Recommendation Report for Planning Permission

REF NO: AL/56/22/PL

LOCATION: Boundary wall to Nyton House
Nyton Road
Westergate
PO20 3UL

PROPOSAL: Part demolition of boundary wall to form new access to existing site (resubmission following AL/10/22/PL). This application may affect the setting of a listed building and is in CIL Zone 3 (Zero Rated) as other development.

12M RIGID VEHICLE ENTERING THE SITE

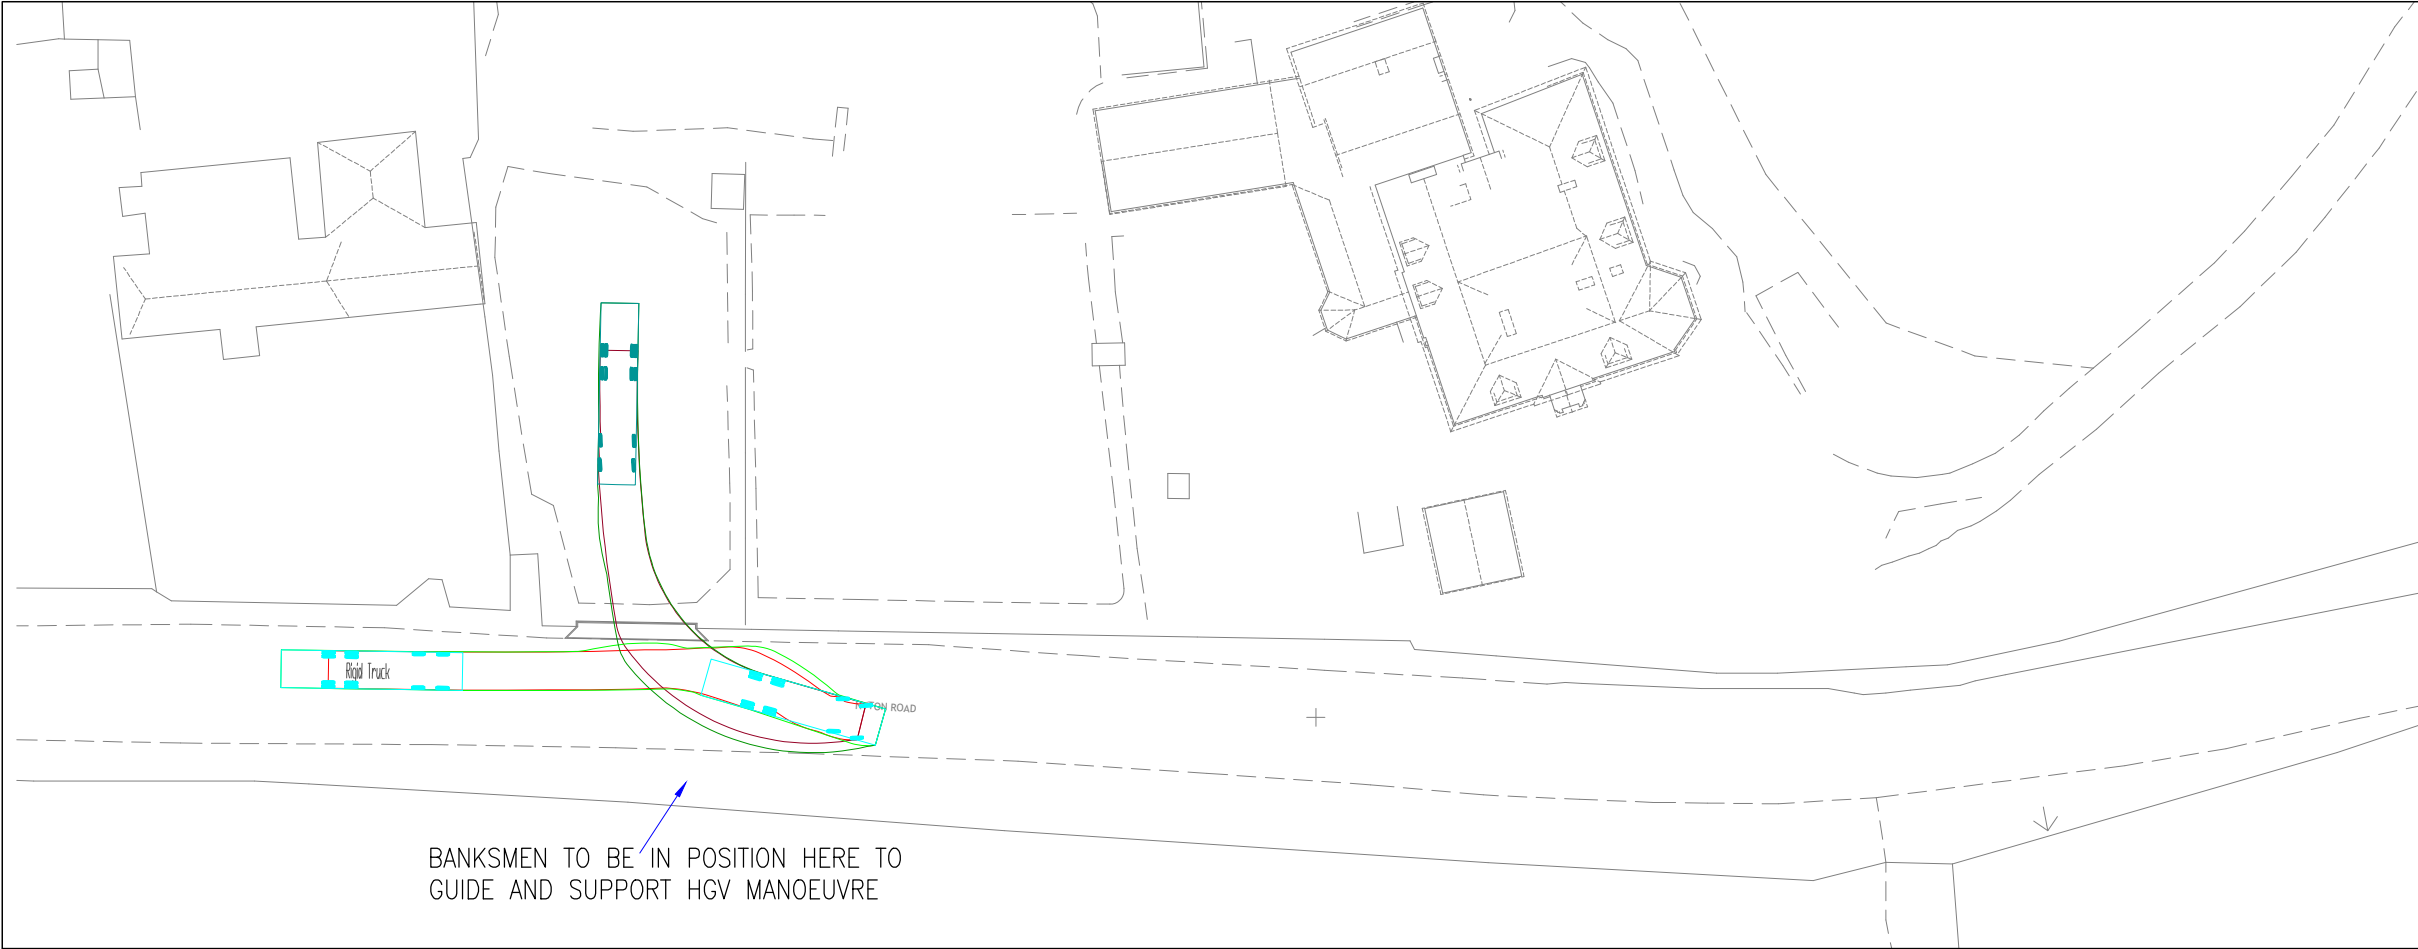
It is appreciated that this access is sought to facilitate construction traffic associated with the implementation of AL/42/19/PL. As part of this permission a Construction Method Statement which includes how delivery of plant / materials and other vehicular activity associated with the build will be managed should be submitted. This has been submitted in support of this application that makes an assurance to implement suitable traffic management at this access point while being used for construction, this is welcomed. It is noted that the construction phase is anticipated to generate in the order of 15 vehicular movements per day. The supporting information includes vehicle tracking to demonstrate how the geometry of the access is suitable for a 16.5m articulated vehicle and 12m rigid body vehicle. These are considered acceptable.

Site Plan
showing proposed works

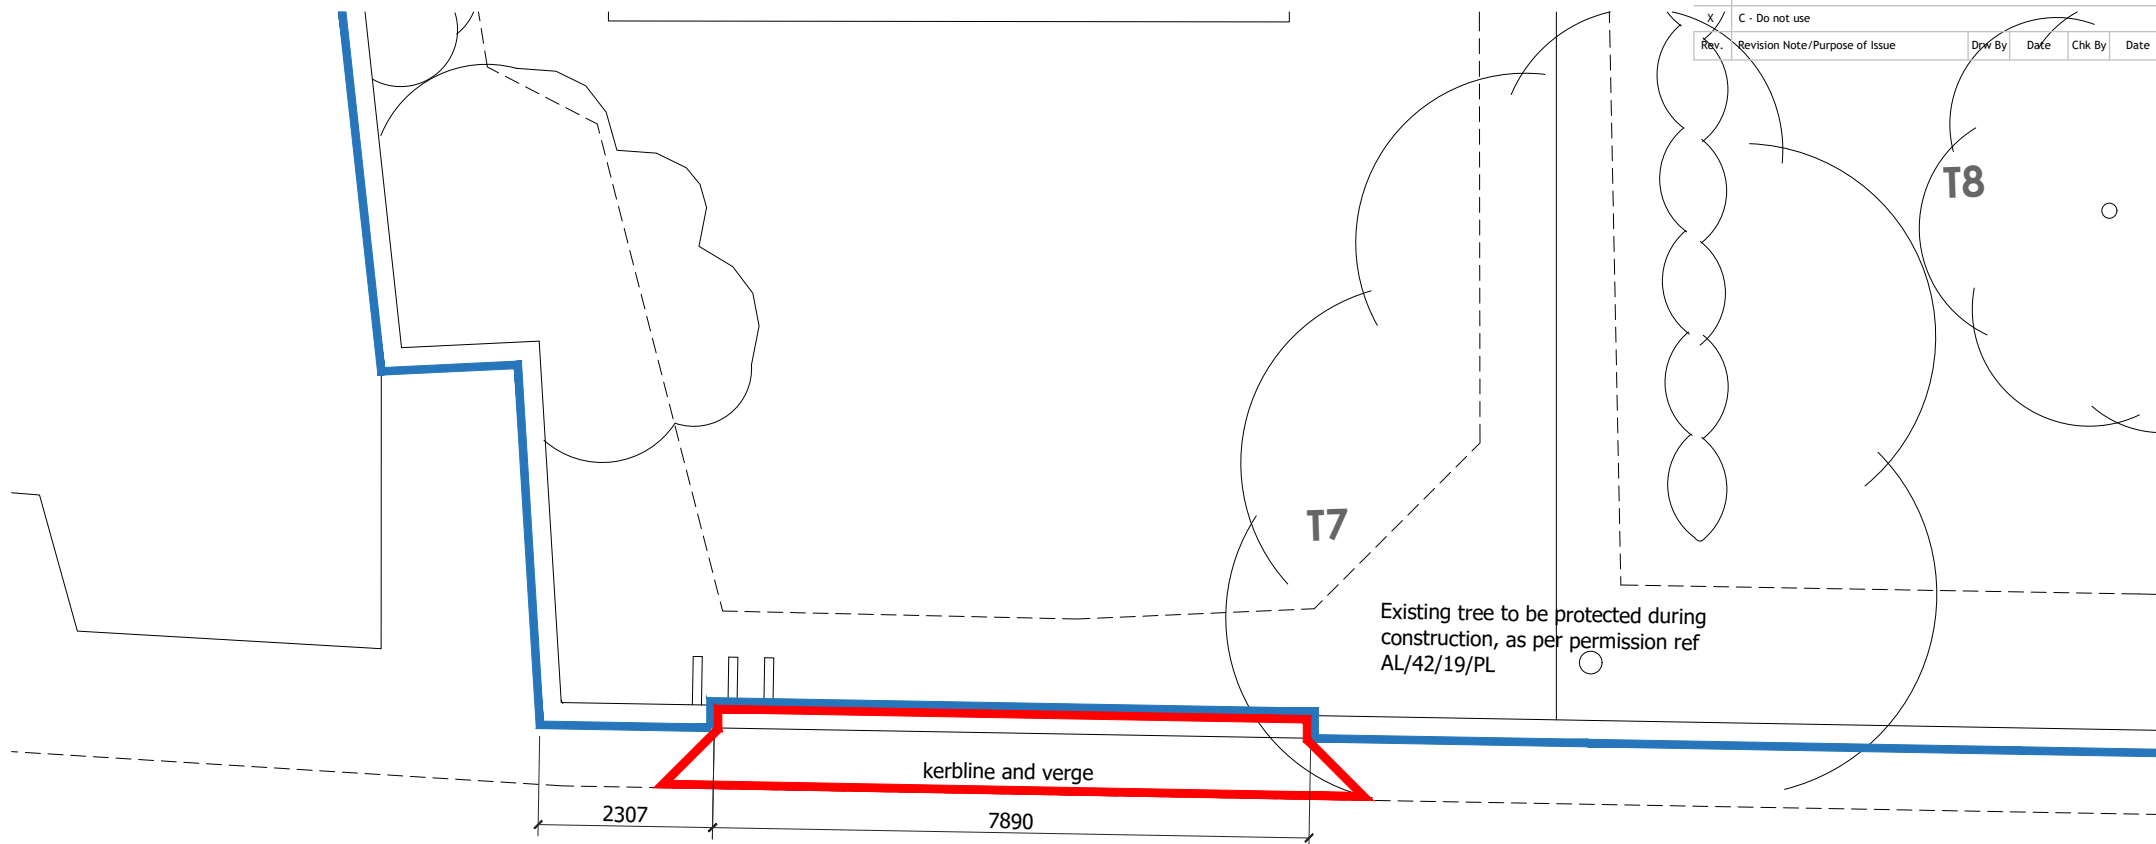
The application relates to the part demolition of the boundary wall to form a new access. This implies that the section of wall is to be removed on a permanent basis. A review of the Design and Access Statement that the wall is to be removed temporarily and reconstructed on completion of construction works. This seems to imply that the section of walling will be re-built when development in the site has taken place. An area of approx. 8m width would be removed as part of this proposal which the agent identifies as containing numerous examples of cracking, dilapidation, and historic damage to this section of the wall. The heritage statement identifies that the works are a necessary alteration in order to facilitate construction works on the site of Nyton House. On its own, the loss of the boundary walling for construction works elsewhere is not an acceptable argument for the loss of historic fabric.

The sensitive repair of the wall is acceptable, and if this would require that this section be removed and replaced so that it looks like it does now, minus the structural issues, this would seem to be acceptable.

It would help to have a more detailed record of the walling so that the reconstruction could be carefully assessed and managed. All existing flint and bricks should be carefully cleaned and retained on site so

that it can be re-used as part of the rebuilt wall. The quality of the rebuild needs to be high and reflect the existing. A sample panel would be required, along with details of the proposed mortar mix - this could be based on an analysis of an existing sample.

It is not clear how the exposed sections of the walling will be treated for the duration of the works, nor how long it is anticipated for the section of walling to be missing. This information should be provided.

The element for removal has a width of just under 8m. However, the wall will only be removed temporarily and reconstructed on completion of the construction works to the main property within the site.

Only this specific section of the wall should be removed, and a detailed record of the walling should be

recorded to ensure that reconstruction could be carefully assessed and managed. All of the existing flint and bricks should be carefully cleaned and retained on site so that it can be re-used as part of the rebuilt wall.

To ensure the quality of the rebuild is high and reflects the existing, a sample panel would be required, along with details of the mortar mix - this could be based on an analysis of an existing sample. A condition was imposed on the supporting Listed application which covers these requirements.

Site Plan
showing visibility splay

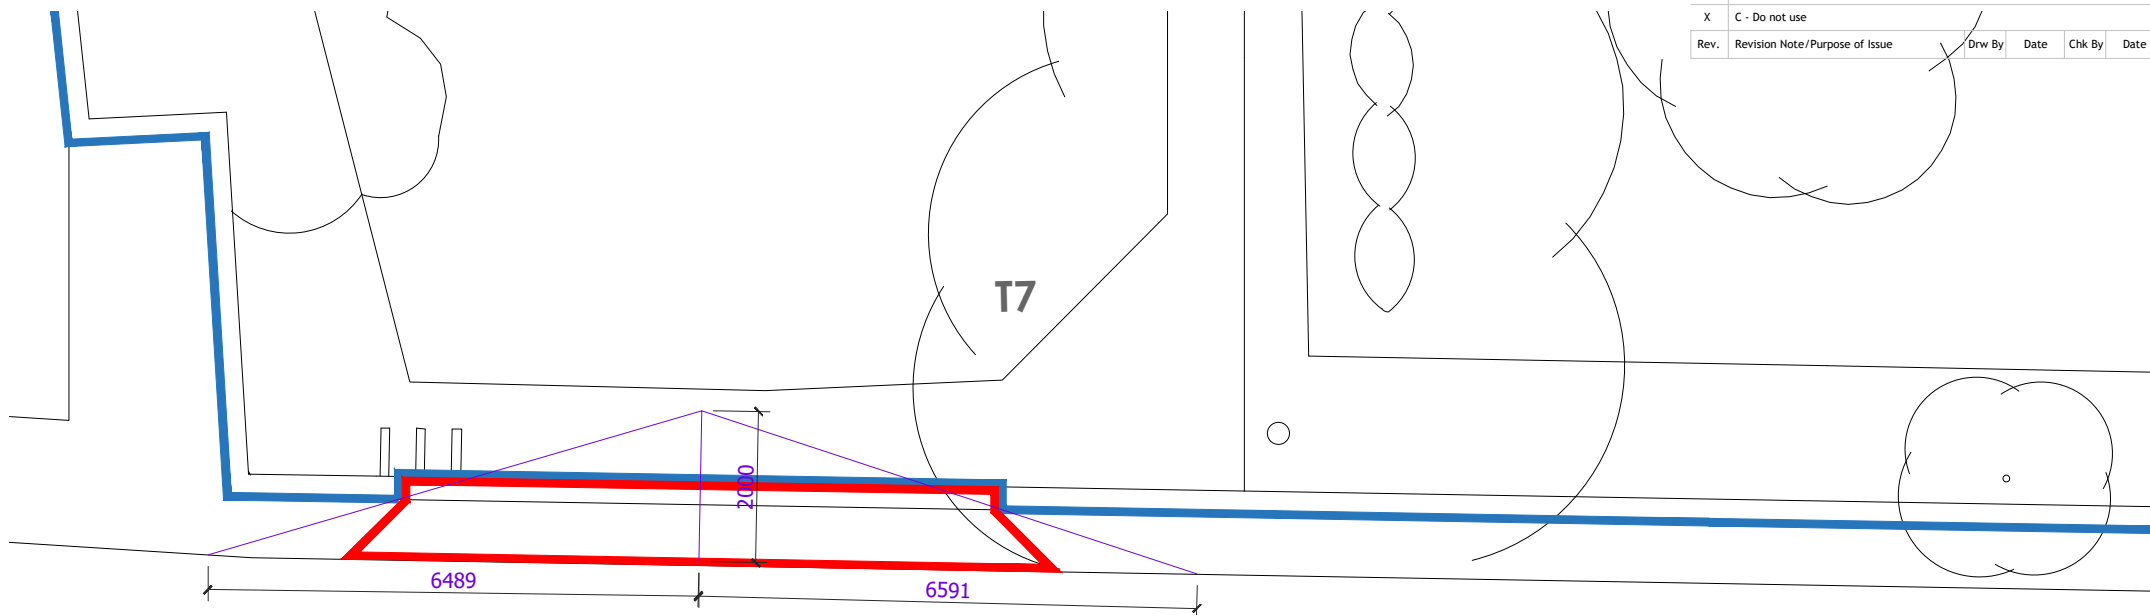
The plans details that the access will be afforded visibility splays of 2.0 x circa 6.5m. A Construction Methods Statement has been submitted in support of this application that makes an assurance to implement suitable traffic management at this access point while being used for construction, this is welcomed. It is noted that the construction phase is anticipated to generate in the order of 15 vehicular movements per day. The supporting information includes vehicle tracking to demonstrate how the geometry of the access is suitable for a 16.5m articulated vehicle and 12m rigid body vehicle. These are considered acceptable. Given the limitations with visibility at the access point, if consent is to be granted, the LHA request the LPA consider applying a suitably worded condition whereby the access point can be used in order to facilitate construction traffic associated with the implementation of AL/42/19/PL, and be used in accordance with the approved details as secured by Condition 3 (Construction Methods Statement) of AL/42/19/PL. Providing such a condition can be applied it would not be anticipated that the proposed would have an unacceptable impact on highway safety.

The access will be afforded visibility splays of 2.0 x circa 6.5m. At the point of the access, Nyton Road is subject to 30mph speed limit although given the nature of the road it is not unreasonable to consider that actual road speeds may be above this.

Given the limitations with visibility at the access point, WSCC recommend a condition is included to specify that access point can only be used to facilitate construction traffic associated with the implementation of AL/42/19/PL and be used in accordance with the approved details within the Construction Method Statement.

- 3 The access point can only be used in order to facilitate construction traffic associated with the implementation of AL/42/19/PL, and be used in accordance with the approved details as secured by Condition 3 (Construction Methods Statement) of AL/42/19/PL.
